CLOVERLEAF FILING NO. 2

A REPLAT OF A PORTION OF TRACT B, WOODMOOR PLACER
 LOCATED IN THE NE1/4 OF SECTION 23 AND THE NW1/4 OF SECTION 24, TOWNSHIP 11 SOUTH, RANGE 67 WEST OF THE 6TH P.M.
 COUNTY OF EL PASO, STATE OF COLORADO

JOB NO. 25158.01
 MAY 7, 2021
 SHEET 2 OF 7

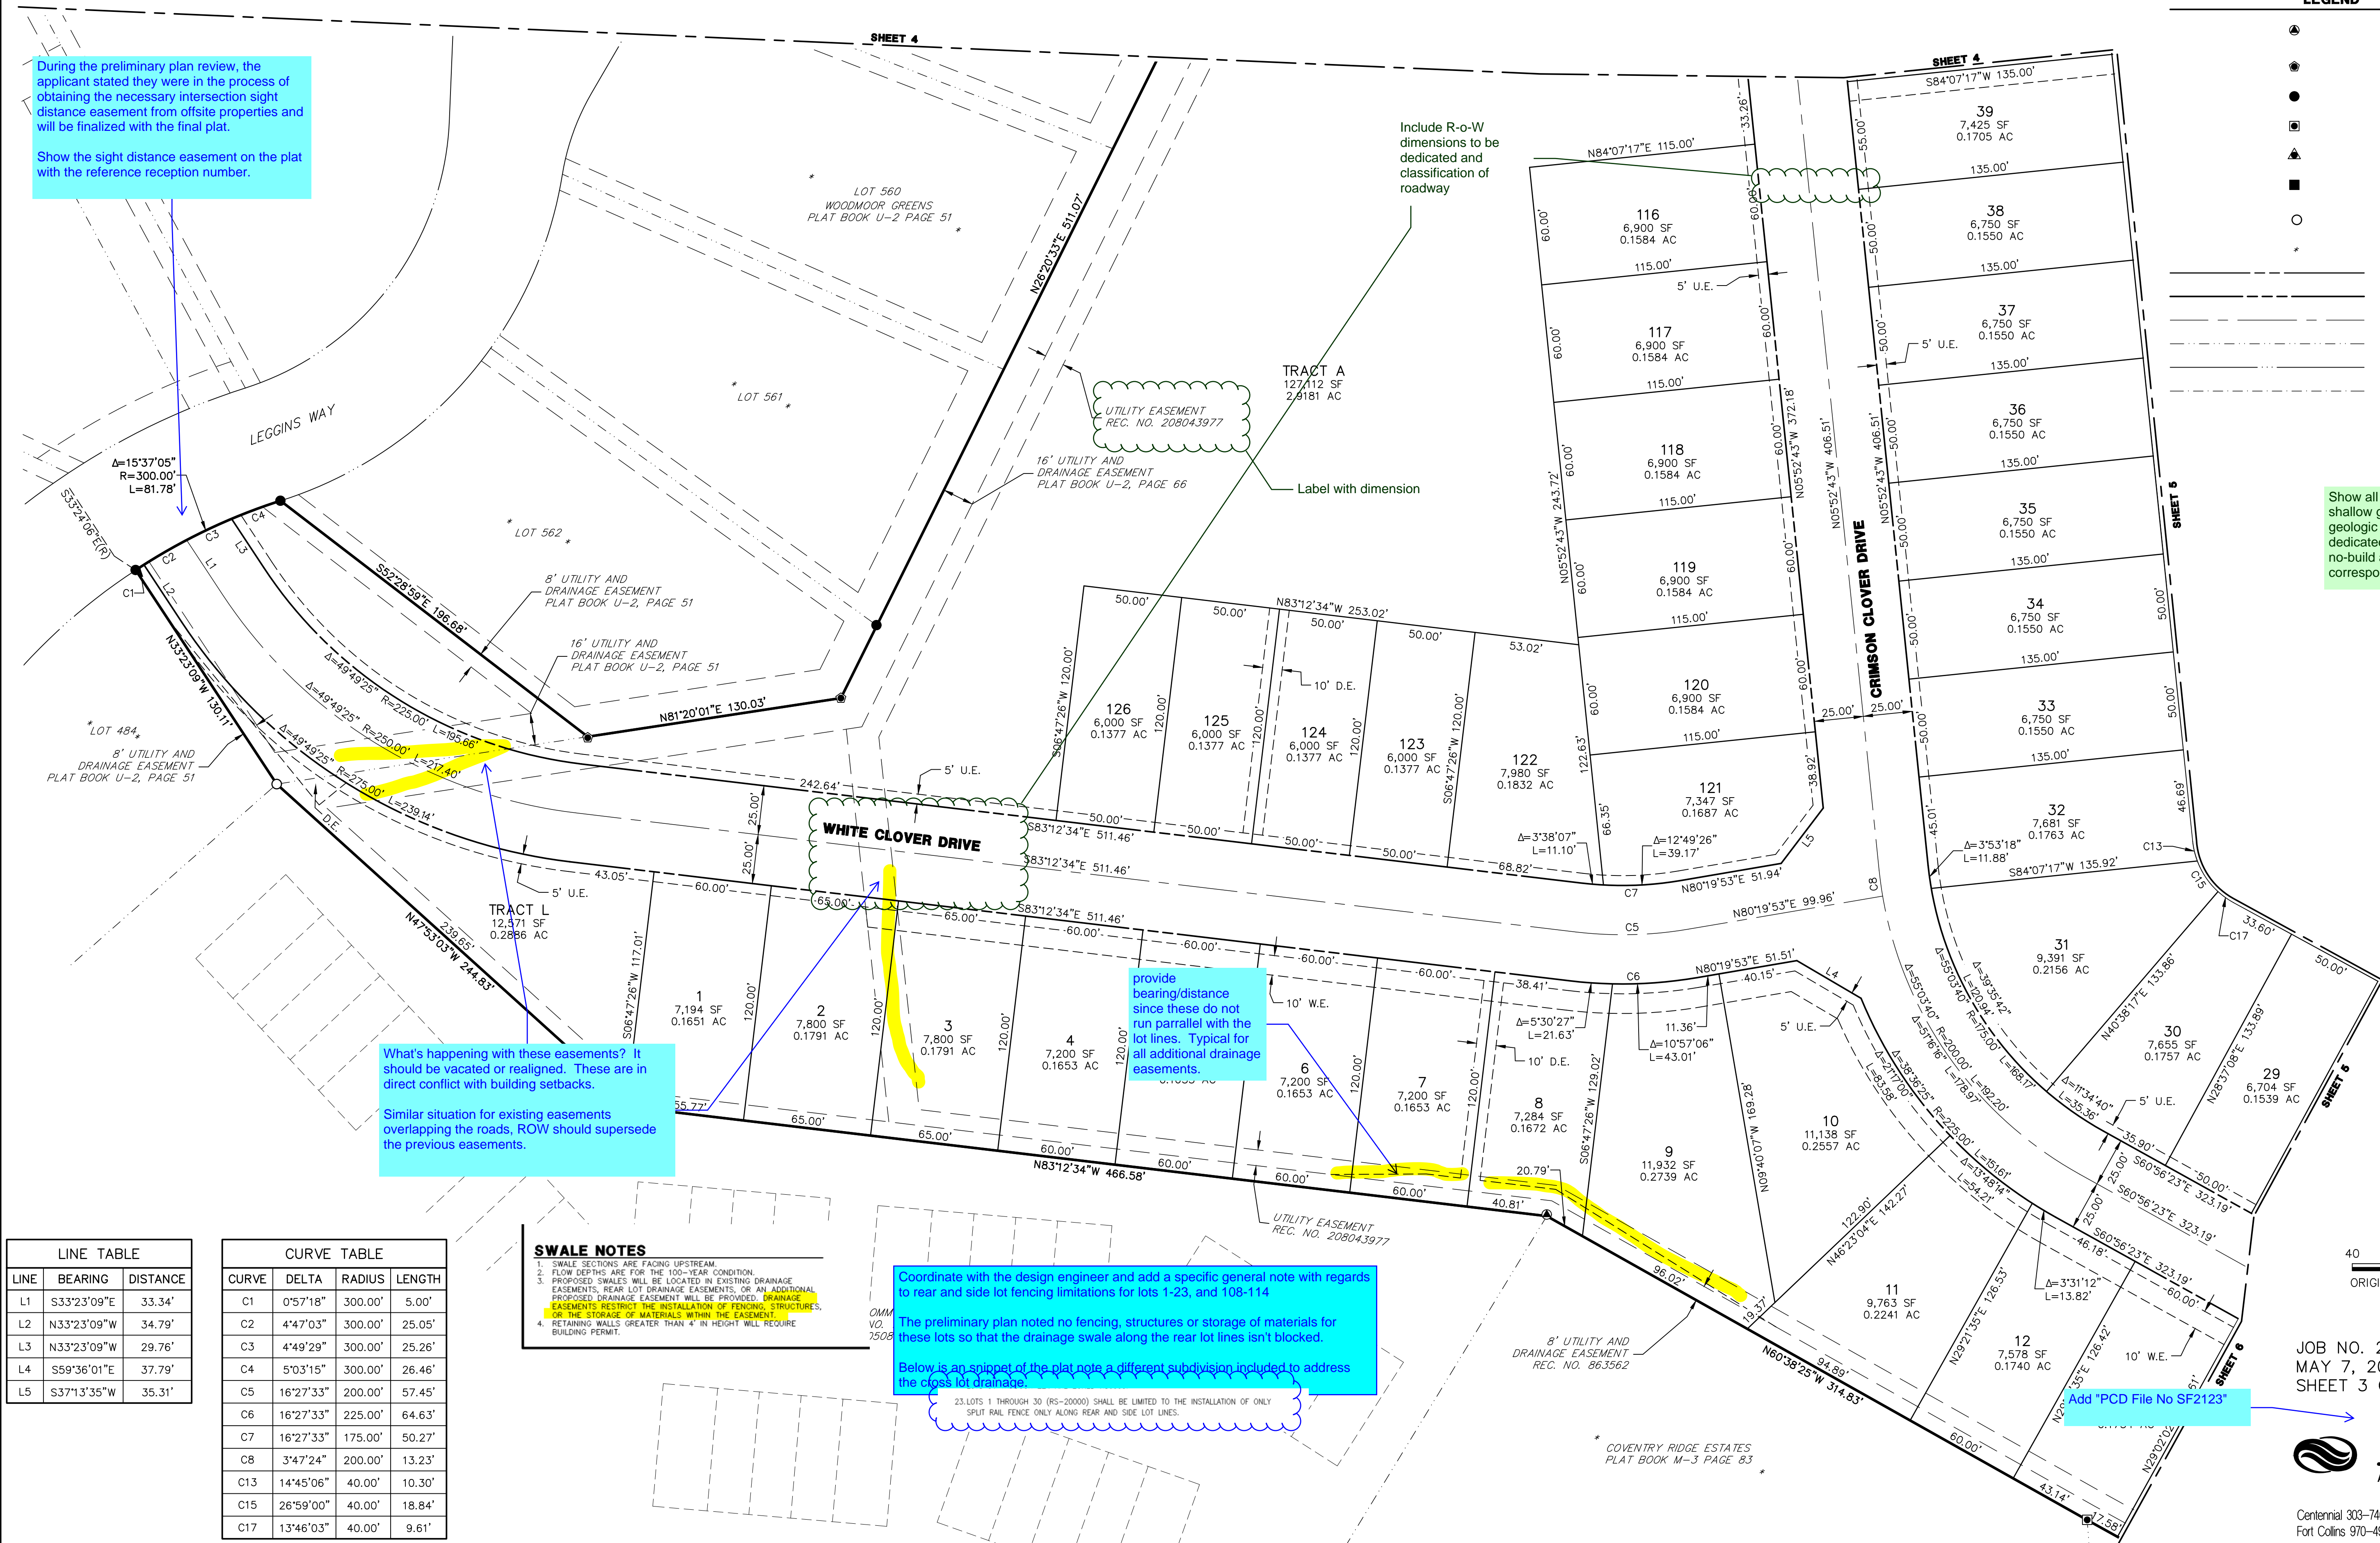
Show all floodplain, shallow groundwater, and geologic hazards dedicated on plat as no-build area and add corresponding notes.

Coordinate with the design engineer and add a specific general note with regards to rear and side lot fencing limitations for lots 1-23 and 108-114. The preliminary plan noted no fencing, structures or storage of materials for these lots so that the drainage swale along the rear lot lines isn't blocked. Below is an snippet of the plat note a different subdivision included to address the cross lot drainage.

Is this an easement? Label with purpose and dimensions if applicable.

Provide the dimension label. The GEC plan shows 22' offset for Lots 112 through 114 drainage easement

Include roadway classification and Row amount to be dedicated

What's happening with these easements? It should be vacated or realigned. These are in direct conflict with building setbacks.

Similar situation for existing easements overlapping the roads. ROW should supersede the previous easements.

Add the reception numbers for all easements being recorded via separate documents.

These are not buildable lots without these easements being vacated.

Not updated Requires further discussion

Revise to 14' per the GEC

Detail added sht 8

Added

Added clarification on vacation request

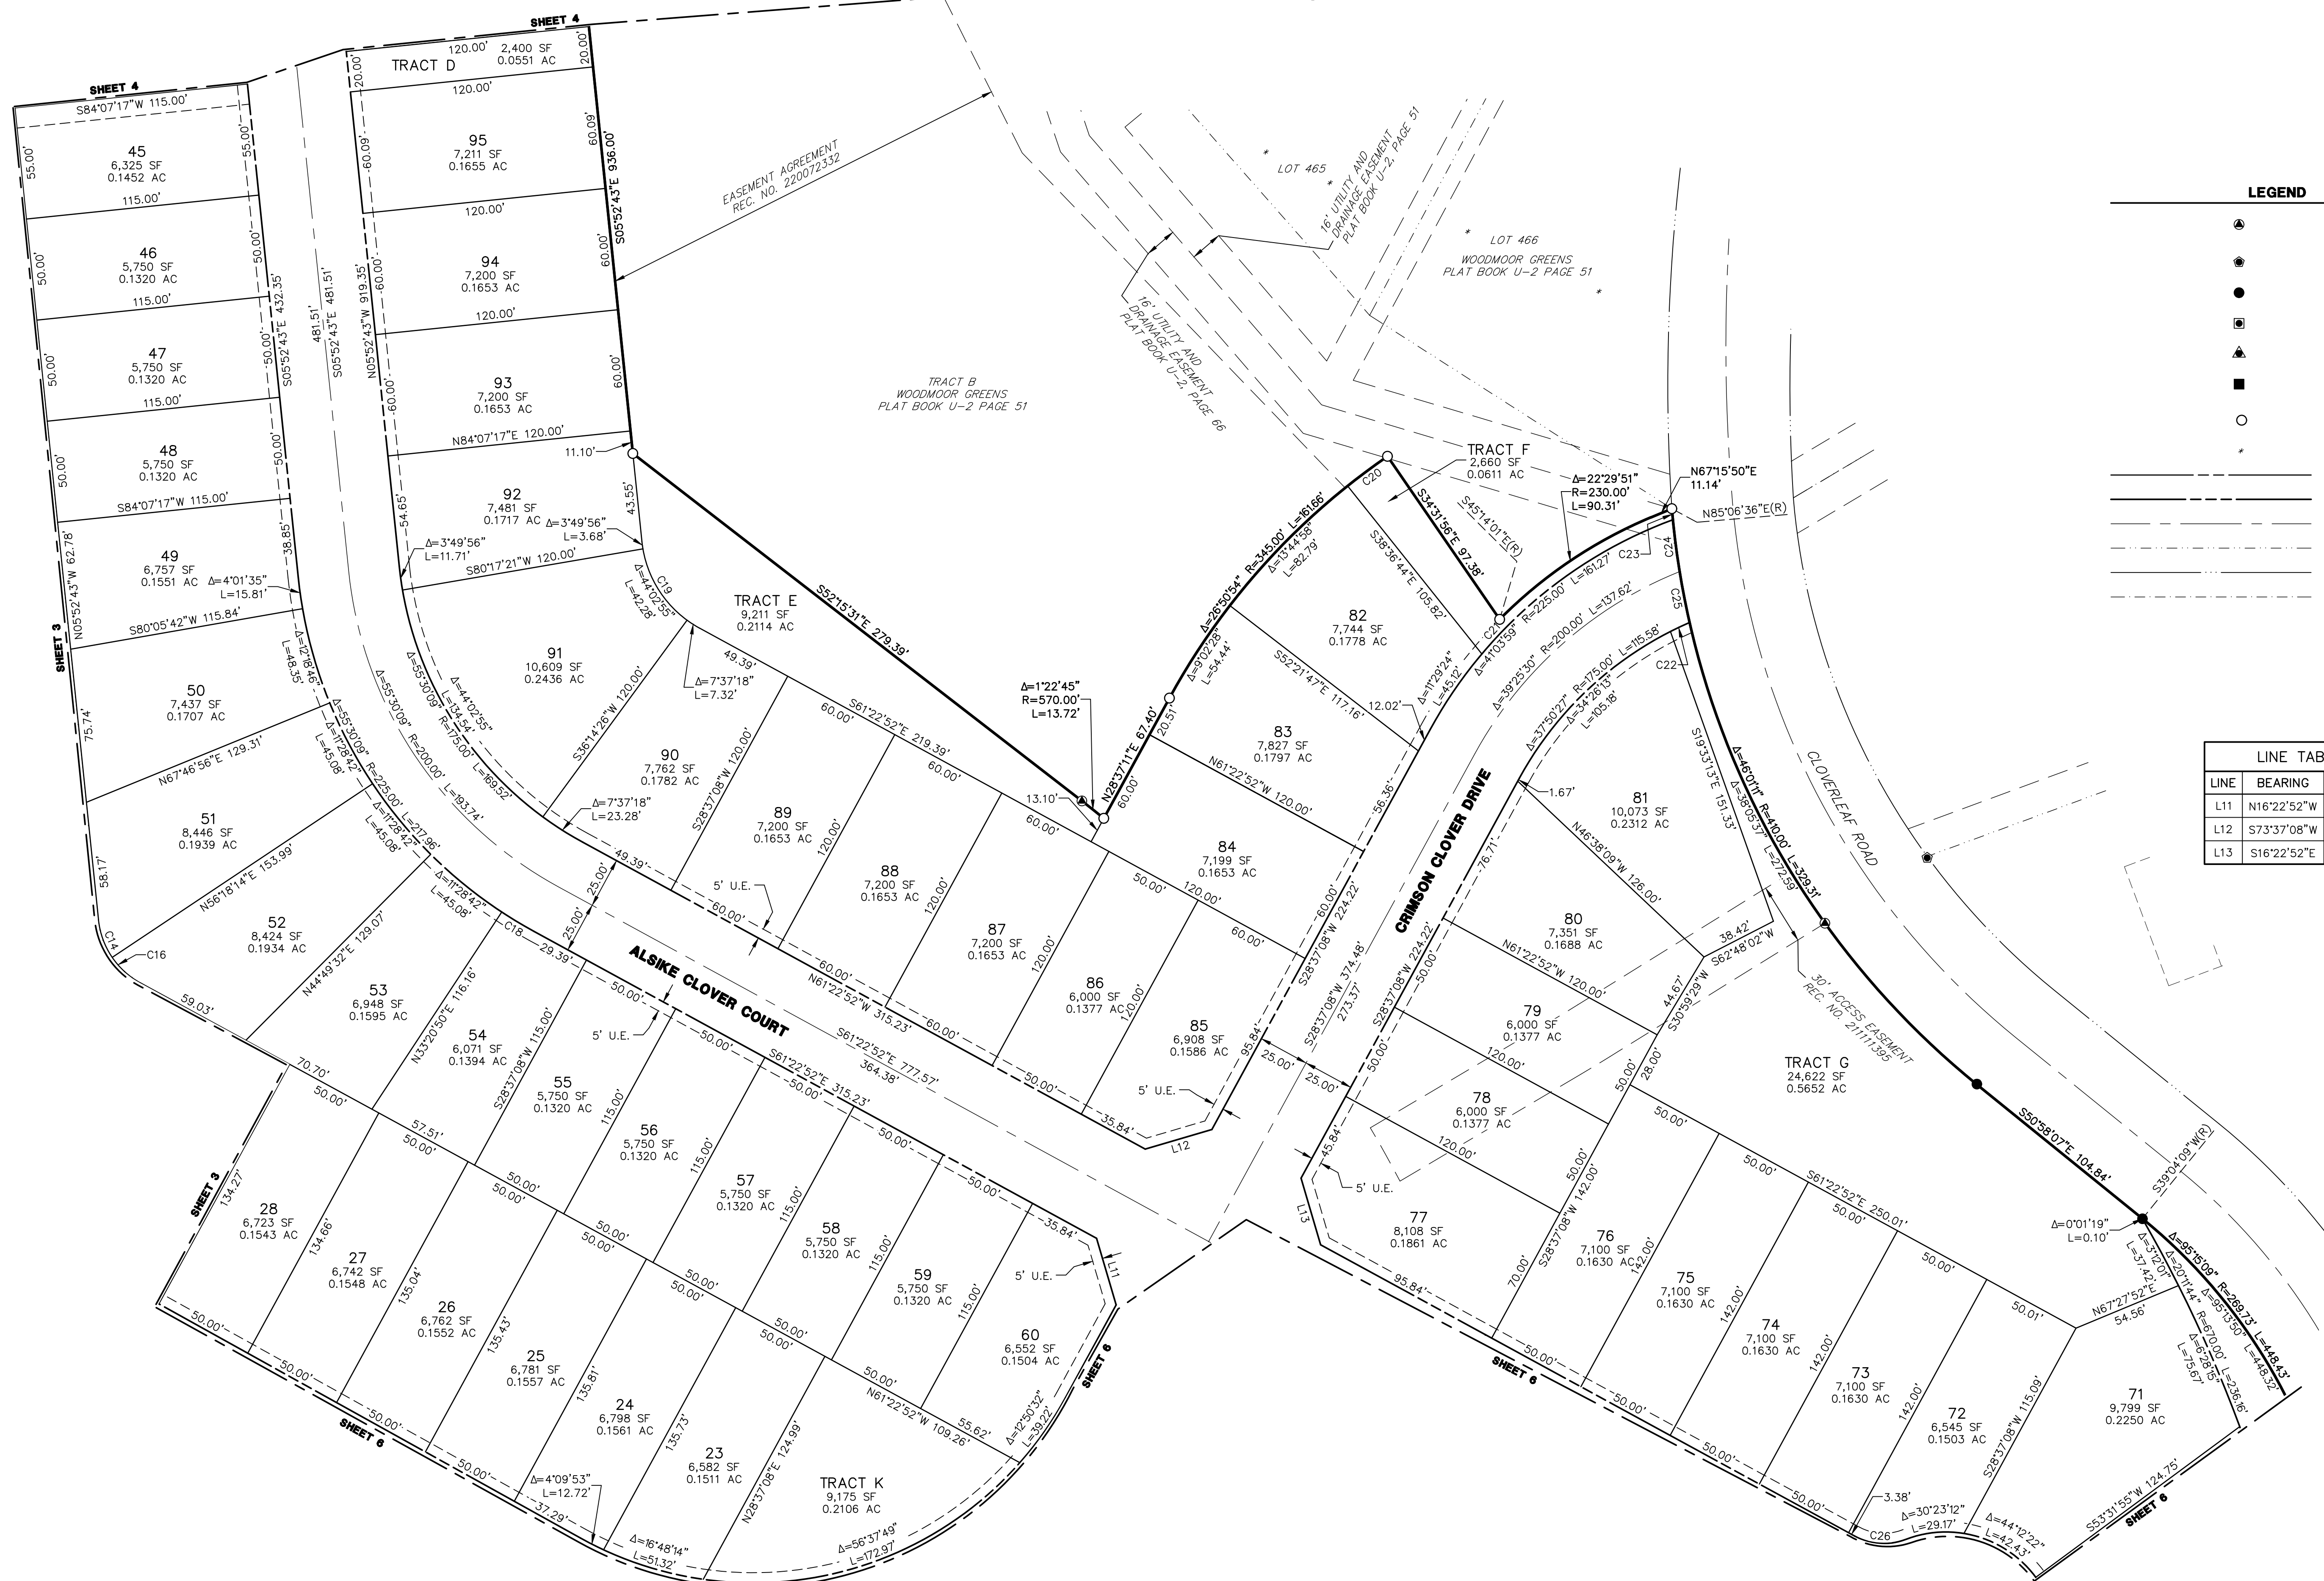
Whats happening with these easements. It should be vacated or realigned. These are in direct conflict with building setbacks. Similar situation for existing easements overlapping the roads. ROW should supersede the previous easements.

To be vacated by separate document
